Comment for planning application 23/03428/OUT

Application Number	23/03428/OUT
Location	OS Parcel 7921 South Of Huscote Farm And North West Of County Boundary Daventry Road Banbury
Proposal	Outline planning application for the construction of up to 140,000 sqm of employment floorspace (use class B8) with ancillary offices and facilities and servicing and infrastructure including new site accesses. Internal roads and footpaths, landscaping including earthworks to create development platforms and bunds, drainage features and other associated works including demolition of the existing farmhouse
Case Officer	Chris Wentworth
Organisation Name	
Name	Mrs Faye Wright
Address	29 Banbury Road, chacombe
Type of Comment	Objection
Type	neighbour
Comments	<p>1) The proposal is located on an unallocated site and development would represent an urbanising form of development which by reason of its location and proposed land use would result in a cluster of large warehouse buildings poorly related to Banbury that would result in a harmful visual intrusion of development into the landscape and open countryside and would therefore result in harm to the rural character, appearance and quality of the ar

JOB TITLE		LAND AT M40 J11		CLIENT		GREYSTOKE	
DRAWING TITLE							
A361 ROUNDABOUT WITH SECONDARY ACCESS							
SCALE	DRAWN BY	DATE	DRAWING No	REVISION			
1:1000@A1	RM	04/12/23	23457-07-01GA	C

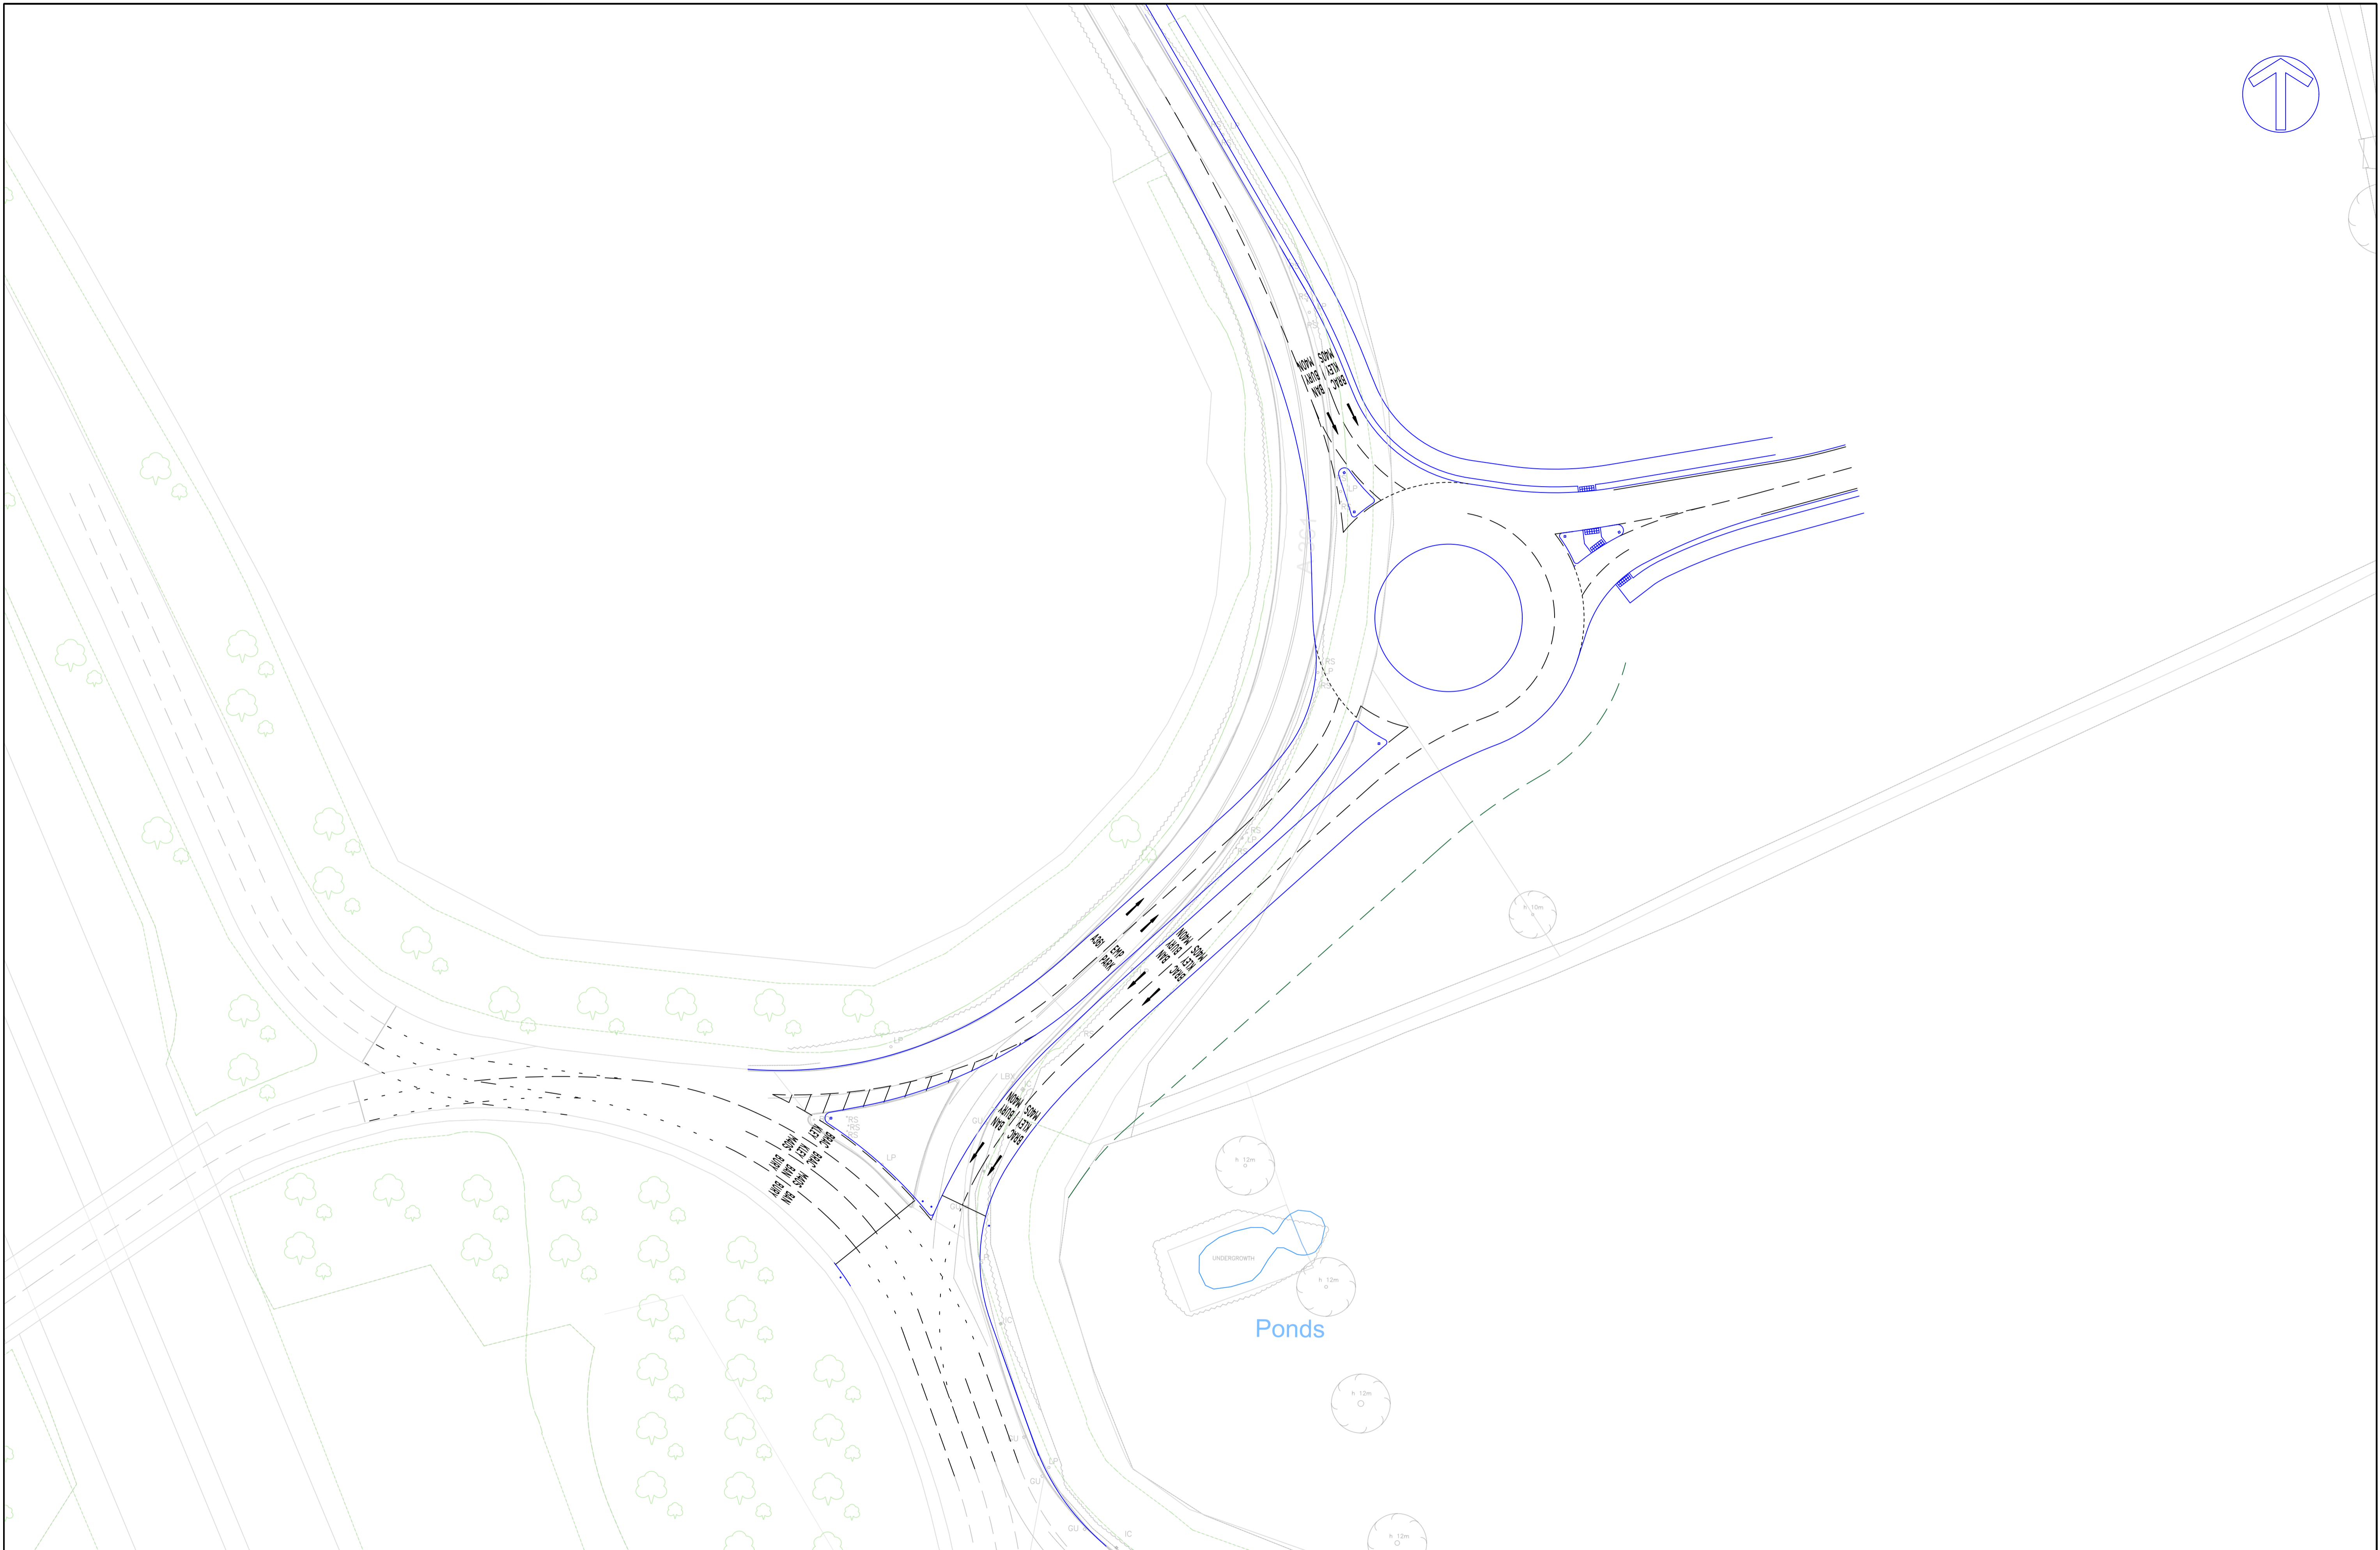
6) It has not been demonstrated that a signalised crossing of the A361 Daventry Road for pedestrians and cyclists may be incorporated at a safe and suitable location, and the associated access into the site has not been indicated. The proposal is therefore contrary to policies SLE1 and SLE4 contained within the Cherwell Local Plan 2011-2031 Part 1 (CLP 2031 Part 1), saved policy TR1 contained within the Cherwell Local Plan 1996 (CLP 1996) and Government guidance within the National Planning Policy Framework.
